# ***City of Albuquerque***

**RE: Grading and Drainage Certification  
Alameda Business Park Lot 46  
(C-16/D006E) (8612 Paseo Alameda NE)  
Engineer's Stamp dated 4/24/2000  
Engineering Certification dated 1/14/2001**

RE: GRADING & DRAINAGE PLAN FOR LOT 46, ALAMEDA BUSINESS PARK (C-16/D06E) ENGINEERS STAMP DATED 4/24/00 SUBMITTED FOR BUILDING PERMIT APPROVAL

RE: GRADING & DRAINAGE PLAN FOR LOT 46 ALAMEDA BUSINESS PARK (C-16/D06E) ENGINEERS STAMP DATED 4/24/00 SUBMITTED FOR BUILDING PERMIT APPROVAL

SITE PLAN & DETAILS

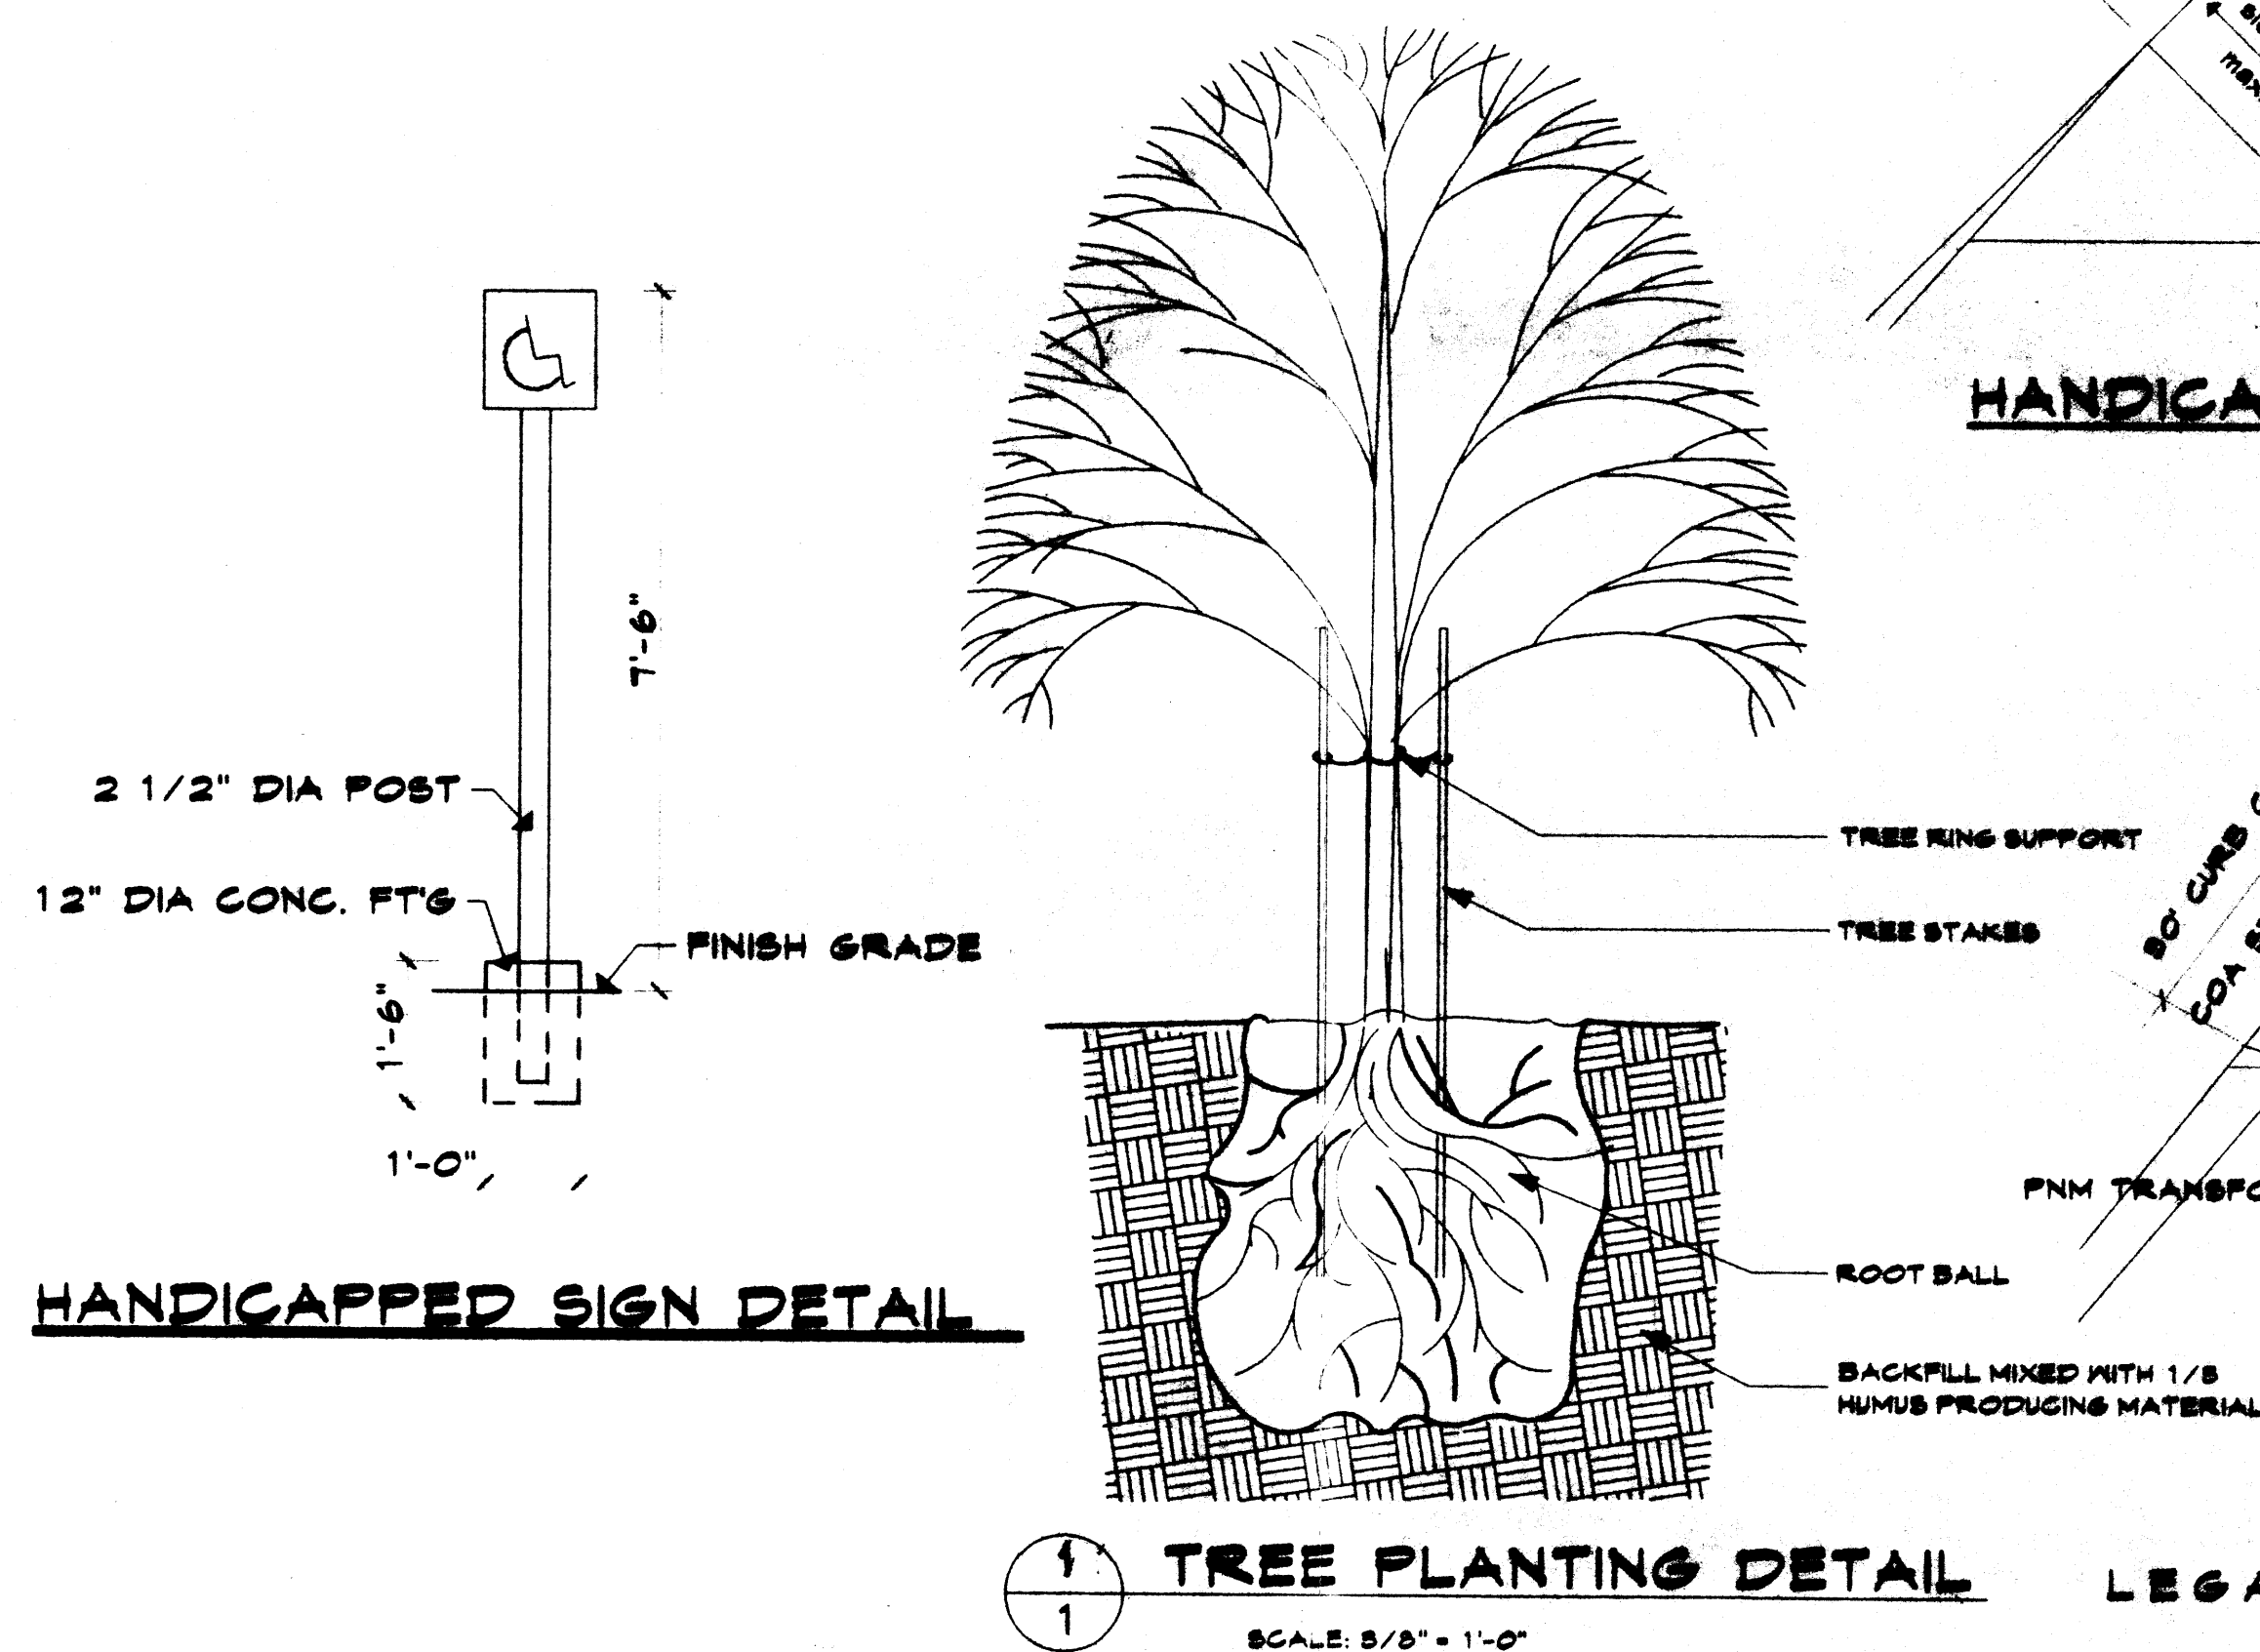
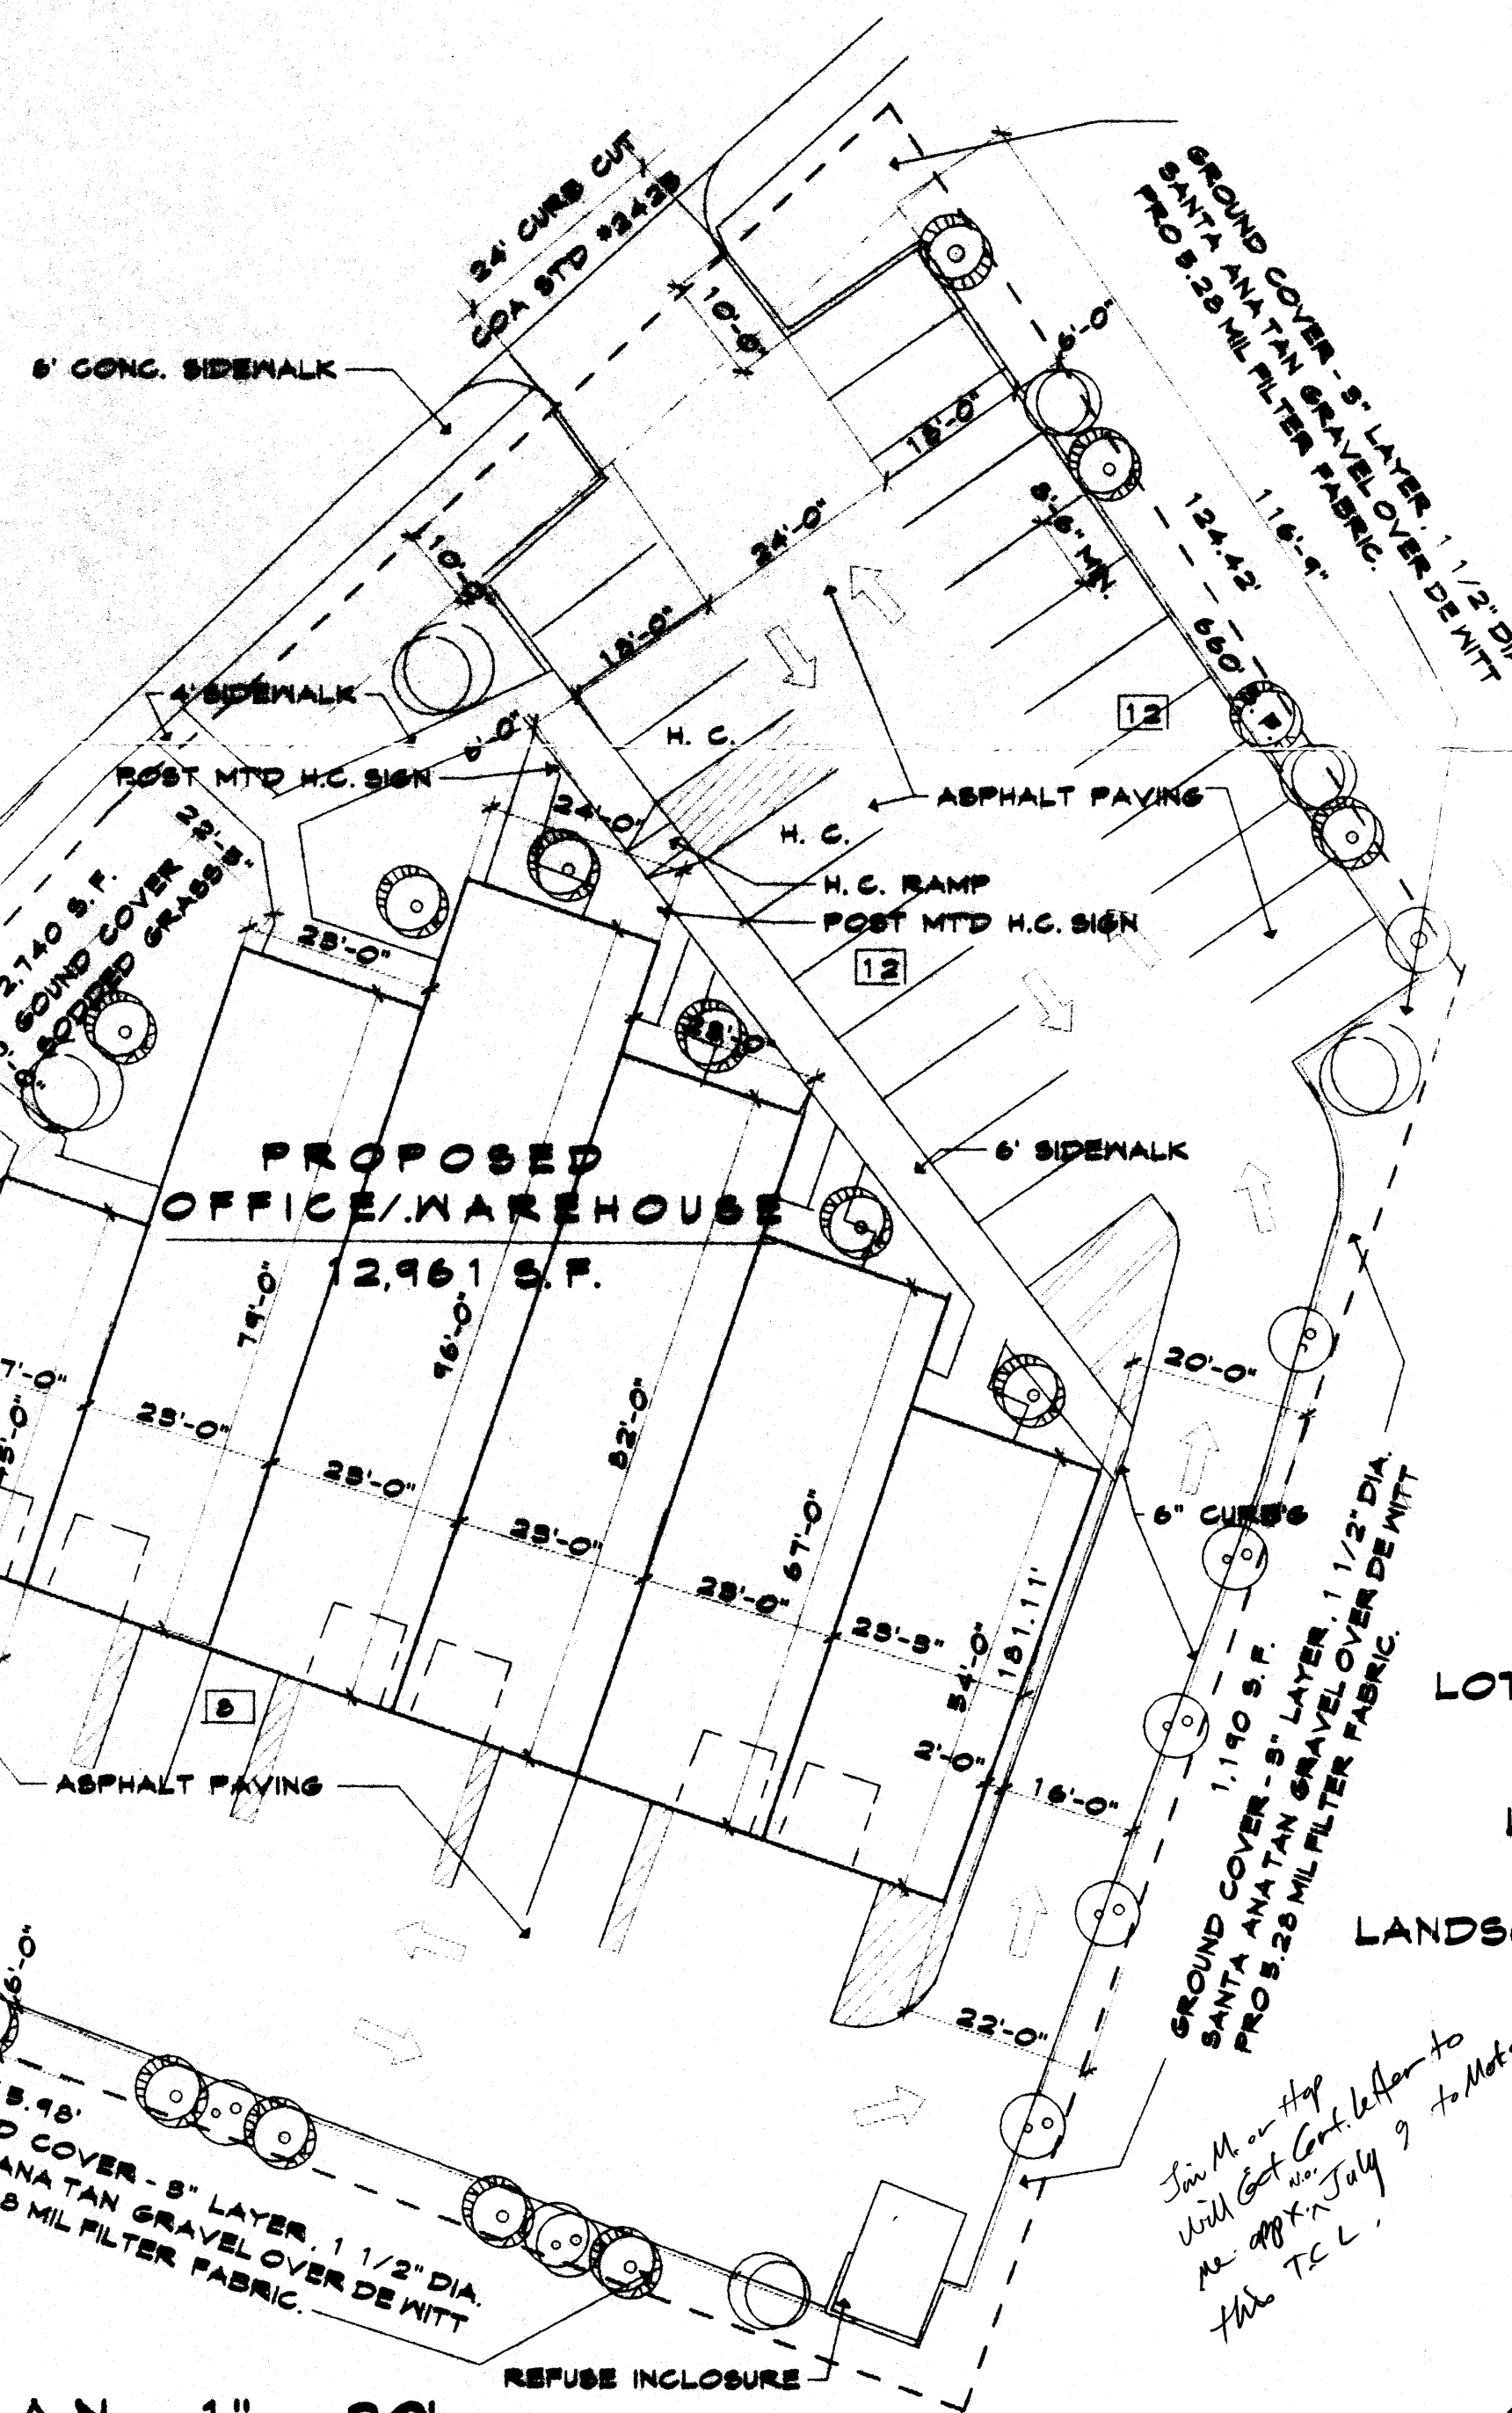
1. The area between the building and the street drains to the street across the sidewalk, in violation of city policy. Please channel the flows through a sidewalk culvert or change the grading to force the flows out the driveway(s). If a sidewalk culvert is used, please submit two plans so that we can issue an SO 19 for its construction. ANS. AREA IS PROPOSED GRASSED LANDSCAPED AREA(S).
2. Please show the direction of the roof drains on your plan. ANS. ROOF SLOPES SOUTHERLY TO DOWNSPOUTS AND ONTO ASPHALT PAVING.
